Comments on the Applicant's D3 Submissions

This document sets out the comments by Cambridgeshire County Council (**CCC**) on the Applicant's Deadline 3 (**D3**) submissions. The table below provides the relevant paragraph or reference numbers.

2.6 Statutory and Non-Statutory Sites or Features for Nature Conservation Plan P03 [\[REP-3-008\]](#)

Project
East Park Energy

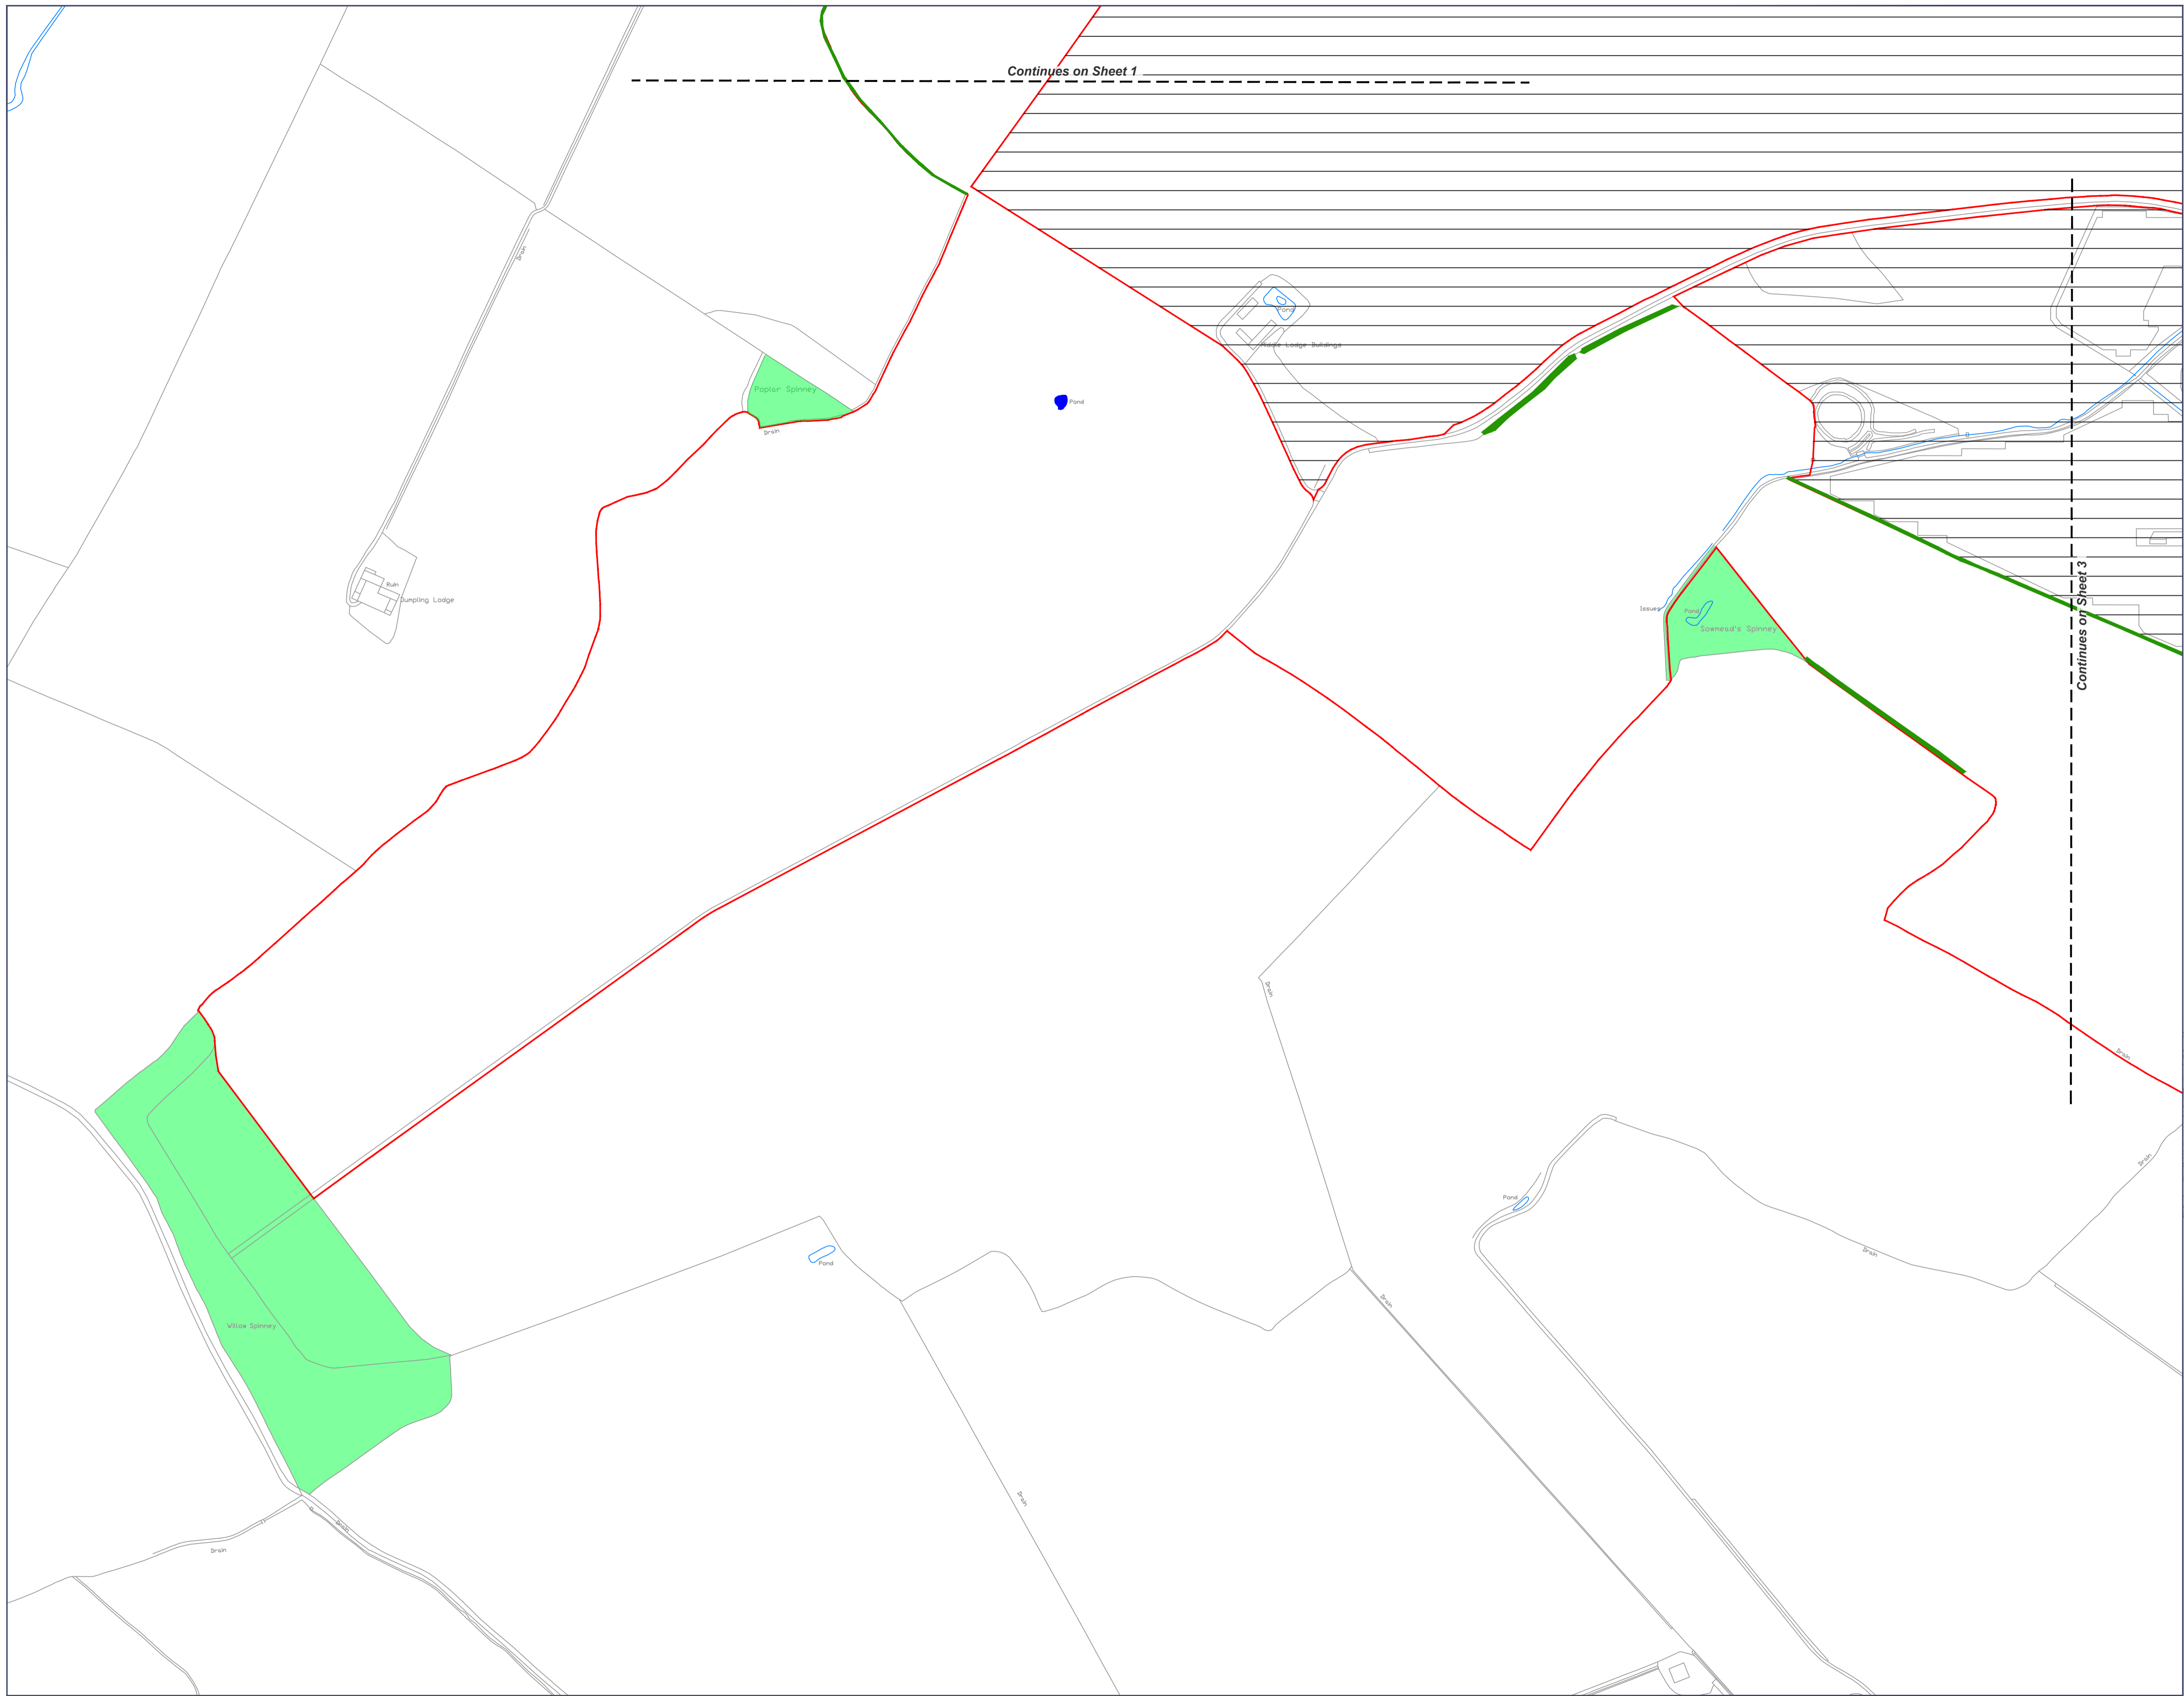
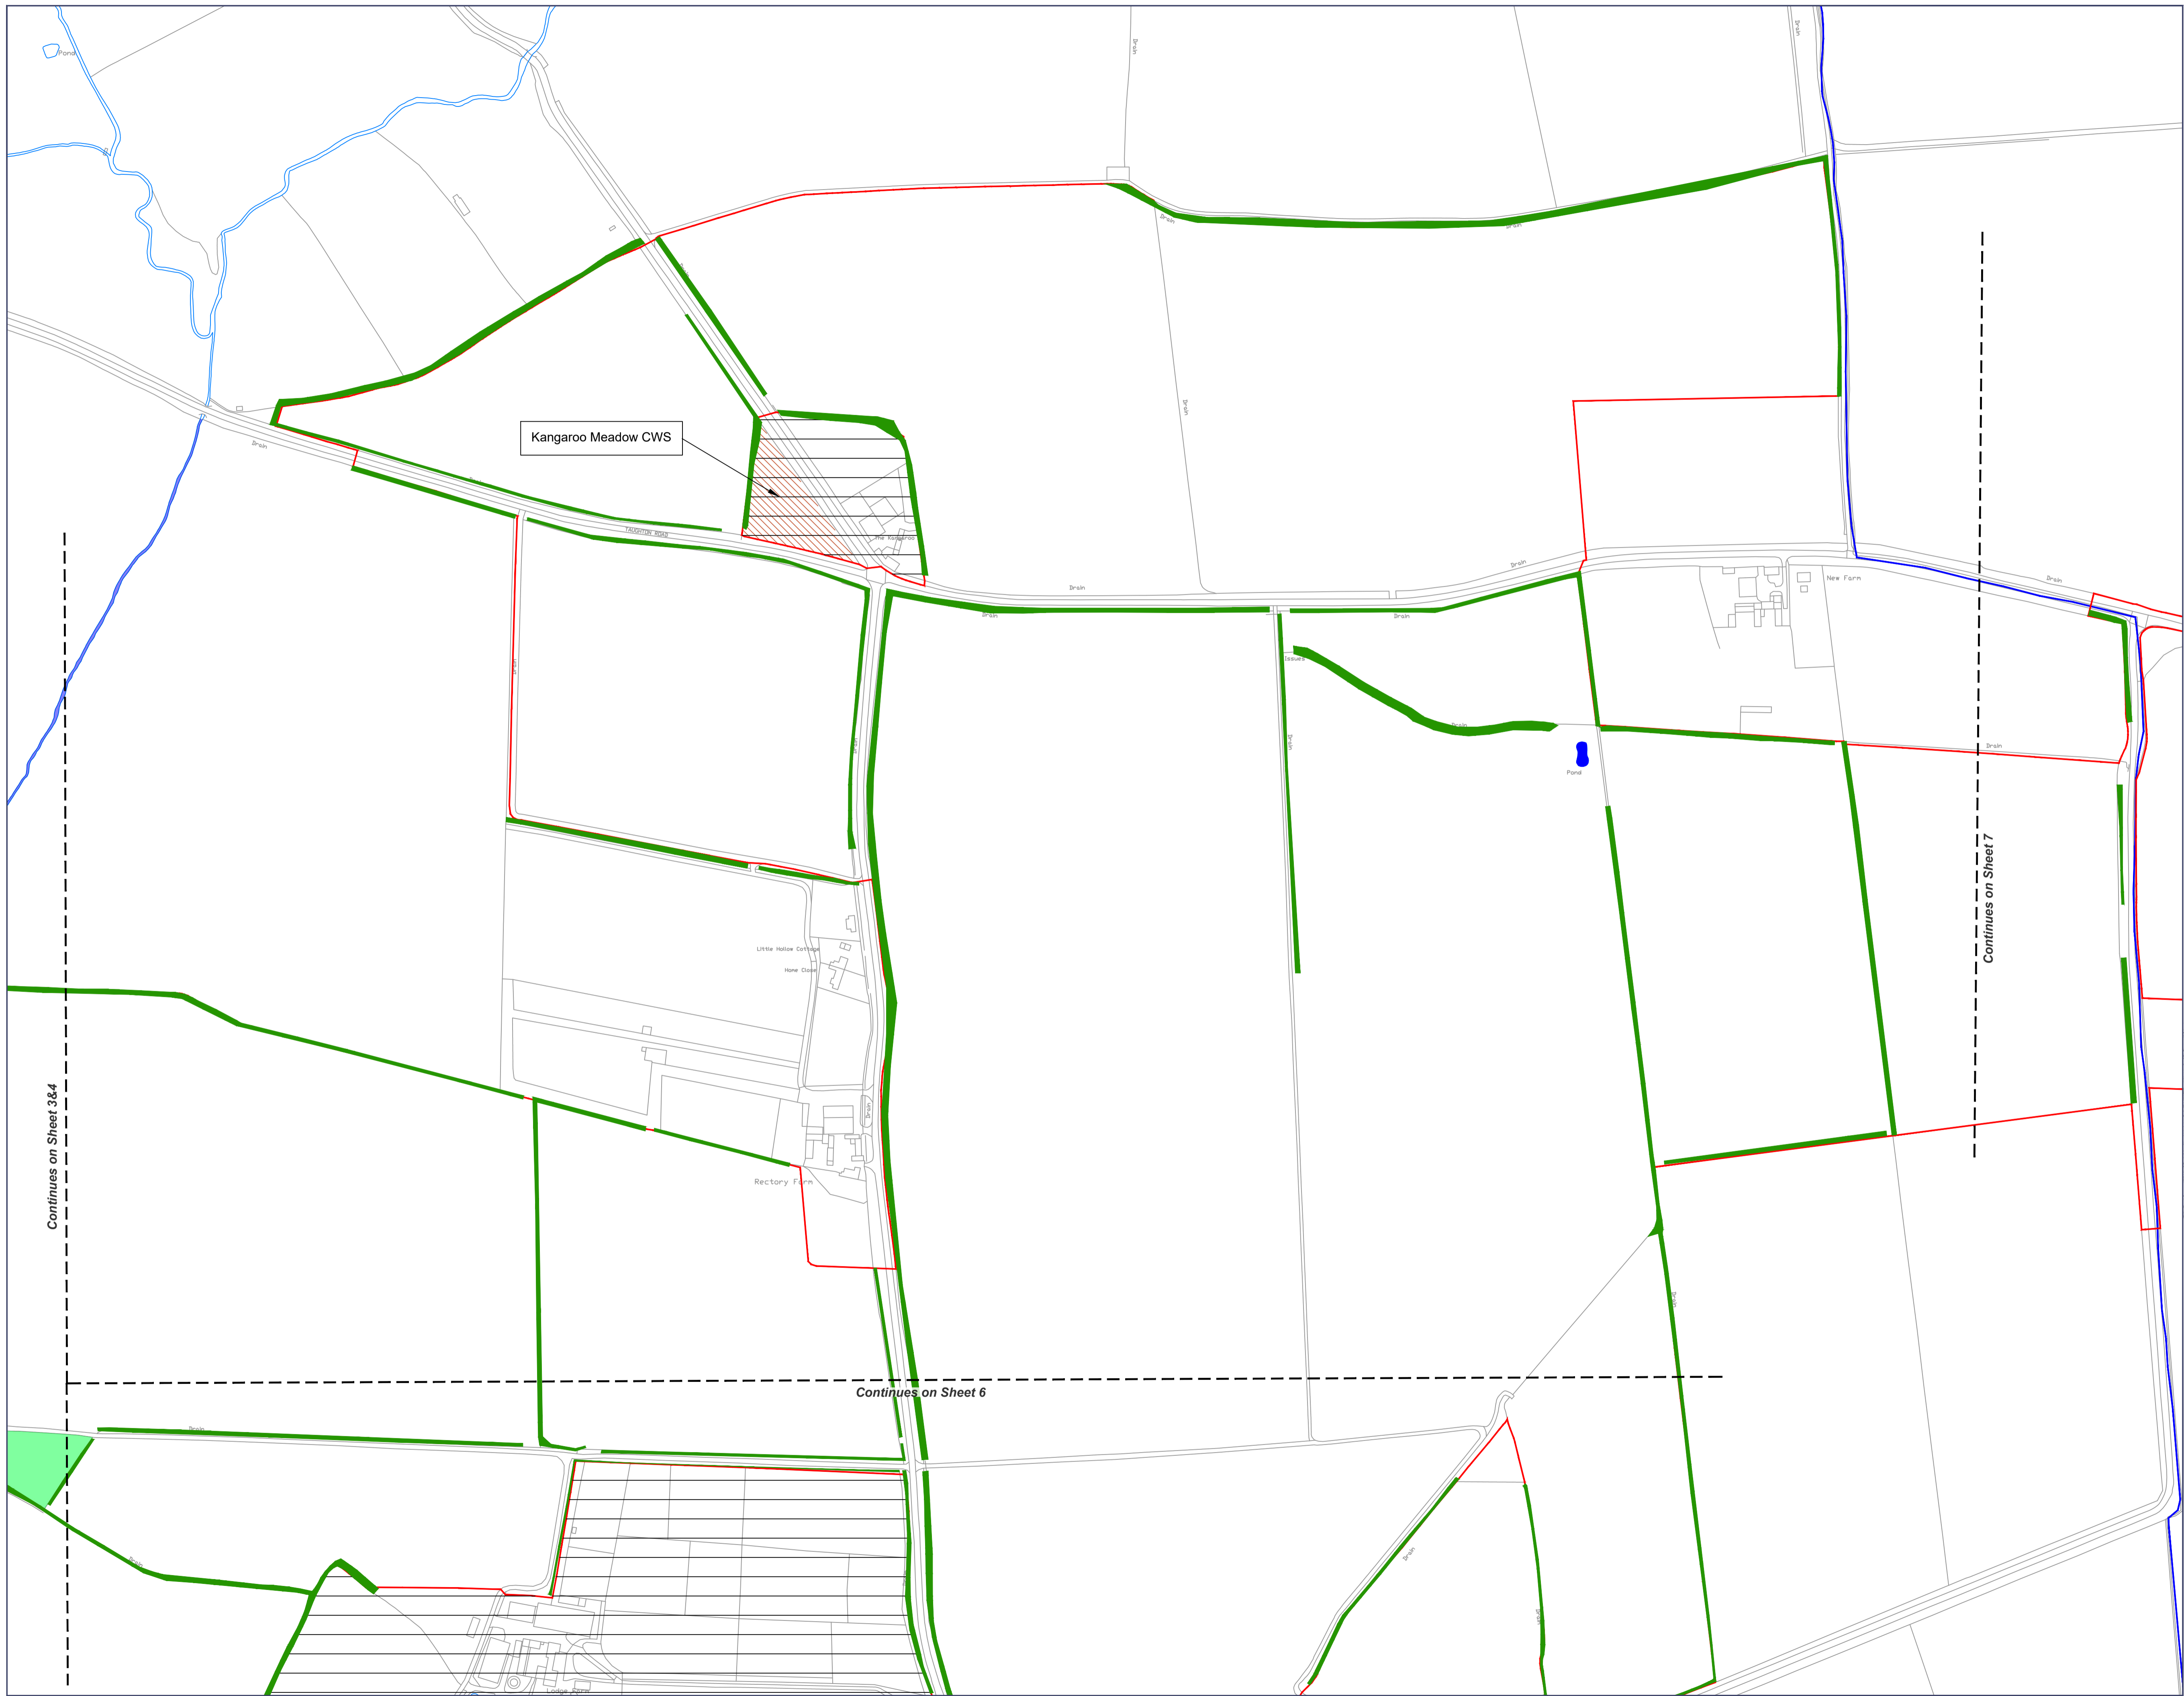
Topic	Paragraph Number	Council's Comments
Irreplaceable habitat	-	For completeness, the council recommend that the drawings are updated to show all irreplaceable habitat that have been recorded within the order limit, or that could be impacted by the scheme. For example, veteran/ancient trees (identified in the tree surveys and considered in the biodiversity net gain calculations).
